# CITY OF ALBUQUERQUE

## OFFICIAL NOTIFICATION OF DECISION

**Project # 1009204**  
12EPC-40015 Site Development Plan for  
Building Permit  
12EPC-40018 Amendment to Zone Map (Zone  
Change)

For the northerly portion of Lot 33, Alvarado Gardens, Unit 1, located on Rio Grande Boulevard NW between Contreras Place & Matthew Avenue containing approximately 1.2 acres.  
Randall Falkner, Staff Planner

A6 EAST ELEVATION (VIEW FROM COURTYARD) WEST ELEVATION (VIEW FROM PARKING)
1/8" = 1'-0"

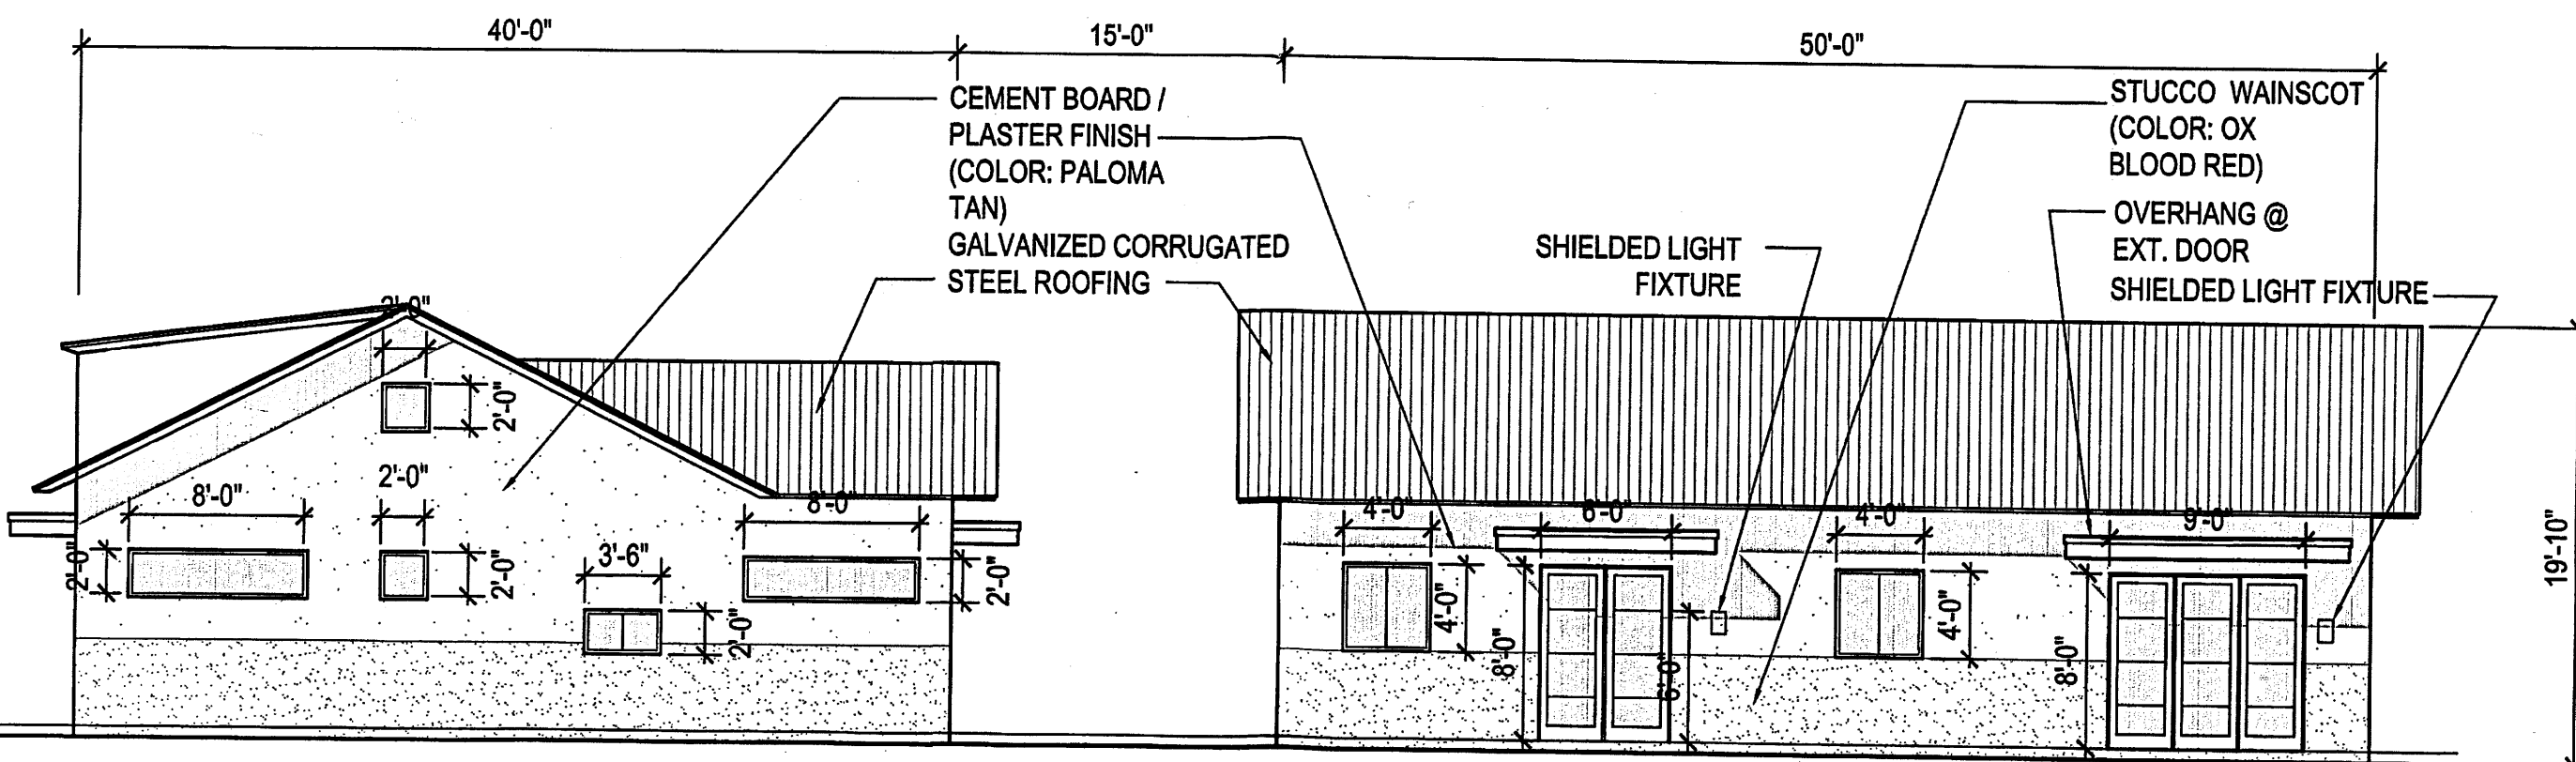
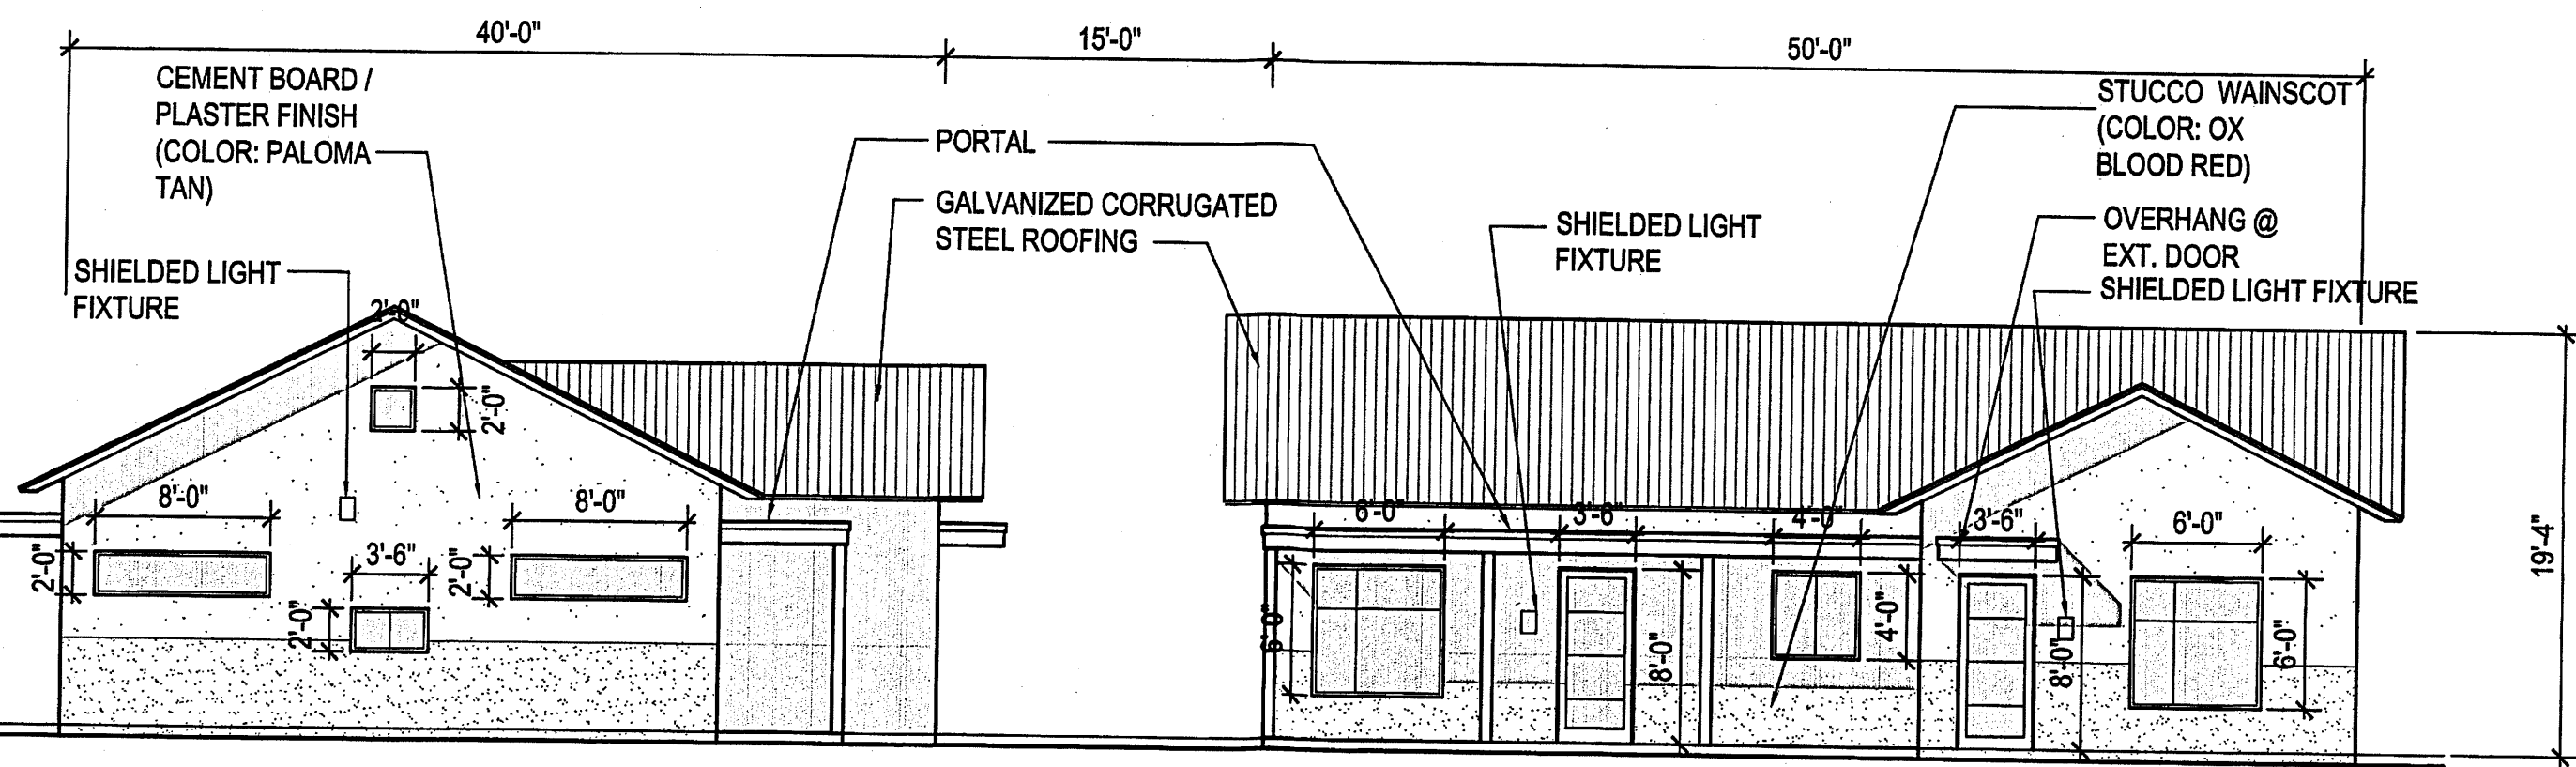
12. The height of the buildings at the top of the pitch shall be a maximum of 24 feet.
13. The EPC supports a variance to the entrance width in order to maintain the existing width of 25 feet.
